20 May 2022

DOC22/325987

# Upper South Creek Advanced Water Recycling Centre (SSI 8609189) EPA Advice on Response to Submissions (RtS)

Figure 6.38 VP21 plan of pipeline outlet (discharge) structure and construction impact area

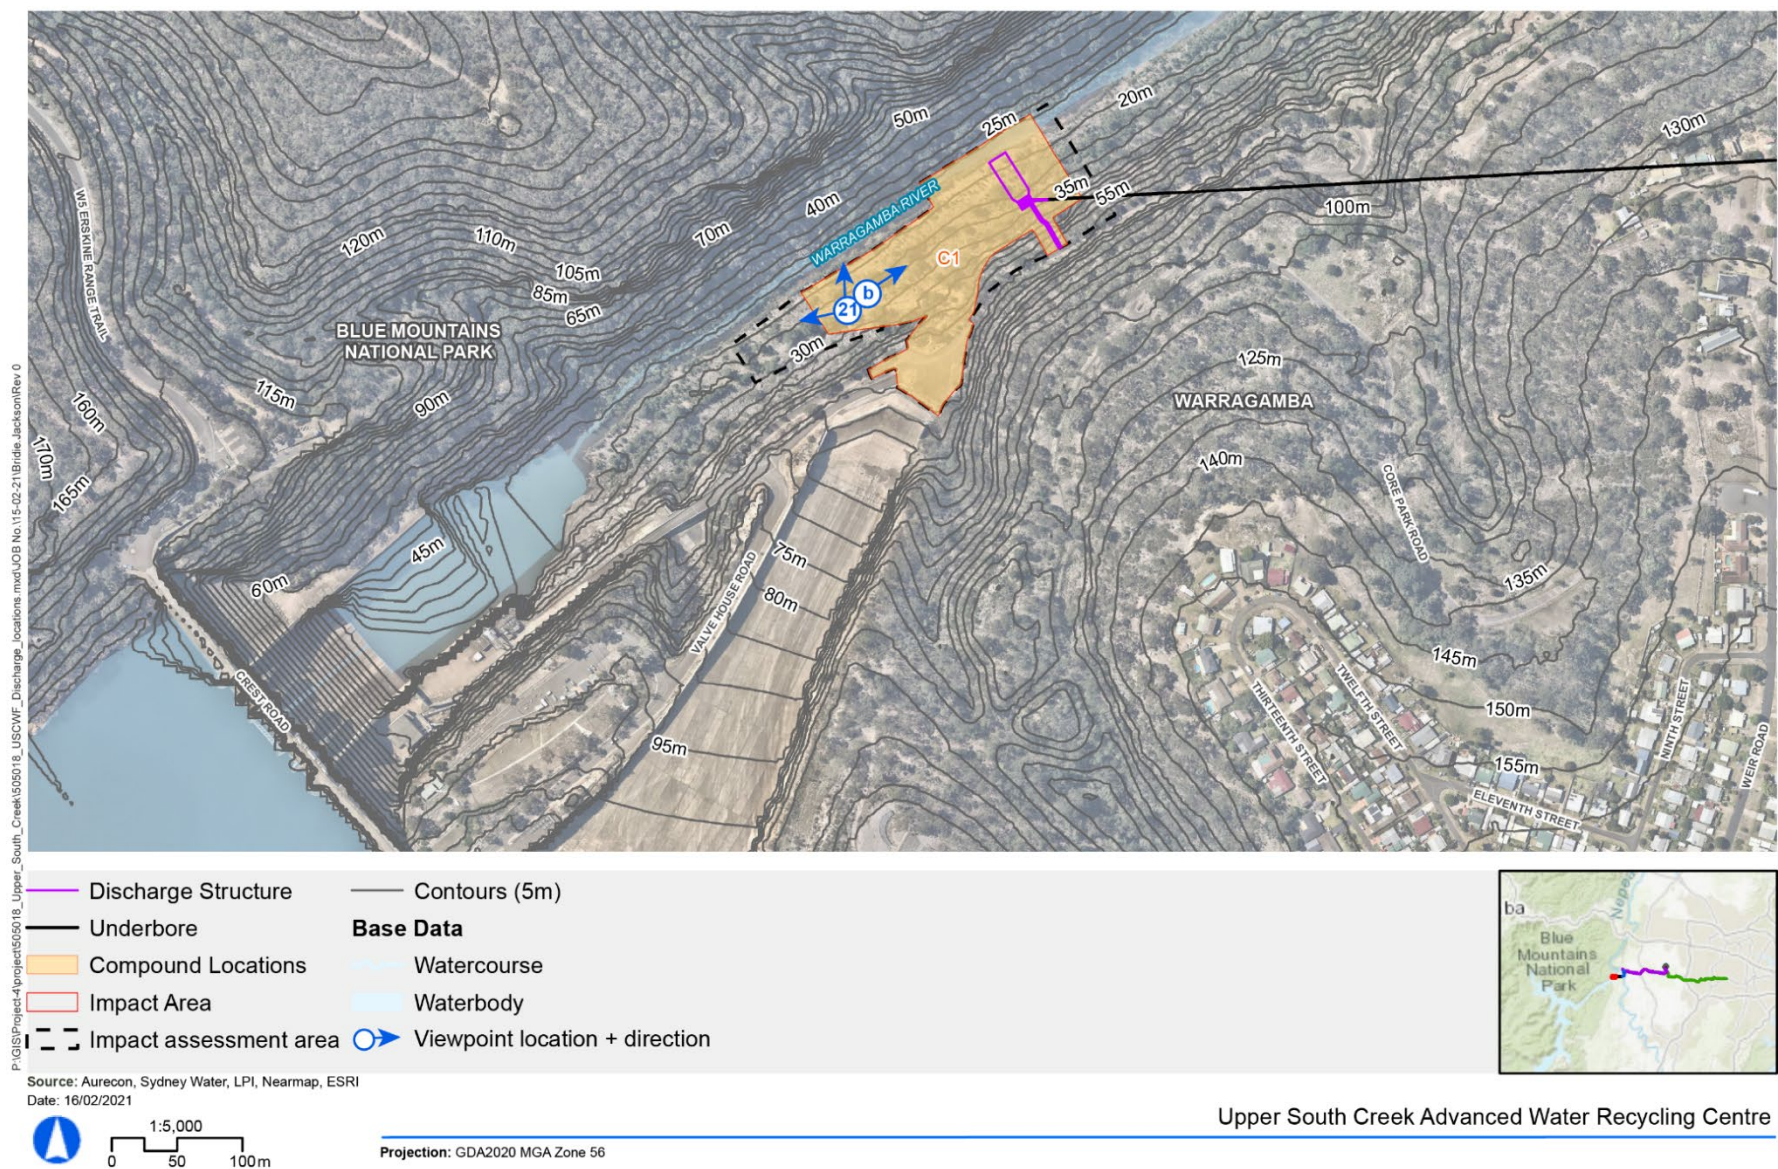
In the RtS report, Sydney Water have considered an alternative discharge configuration (three port diffuser) that provides adequate dilution of Nepean River discharges. While there are identified construction and operational issues associated with this alternative, if these issues can be overcome or mitigated it will significantly reduce the risk to the protection of the environmental values in the Nepean River under severe wet weather conditions and, most likely, also under other rainfall conditions

In the RtS Report, Sydney Water has also committed to investigating opportunities during detailed design to see if there are any feasible opportunities to improve dilution of wet weather releases. While the EPA is supportive of this commitment, further assessment of alternative discharge locations and configurations at this stage of the planning process is considered a more concrete mechanism to identify a more beneficial environmental outcome.

The EPA recommends that Sydney Water consider alternatives to the current proposed location and configuration of the discharges to the Nepean River. The following approaches should be examined in further depth by Sydney Water:

While the potential erosion issues with discharge points further upstream are acknowledged, the EPA considers that further assessment should be given to a discharge location downstream of Wallacia weir. Specifically, this assessment should:

- Outline further the construction issues associated with a downstream location
- Further clarify any recreational areas downstream that may be impacted (if any) and assess the impacts to these areas relative to the current discharge location.
- Model the toxicity impacts of this downstream discharge location compared to current discharge point (including justification that limited levels of dilution would occur relative to the current discharge point during extended dry weather).
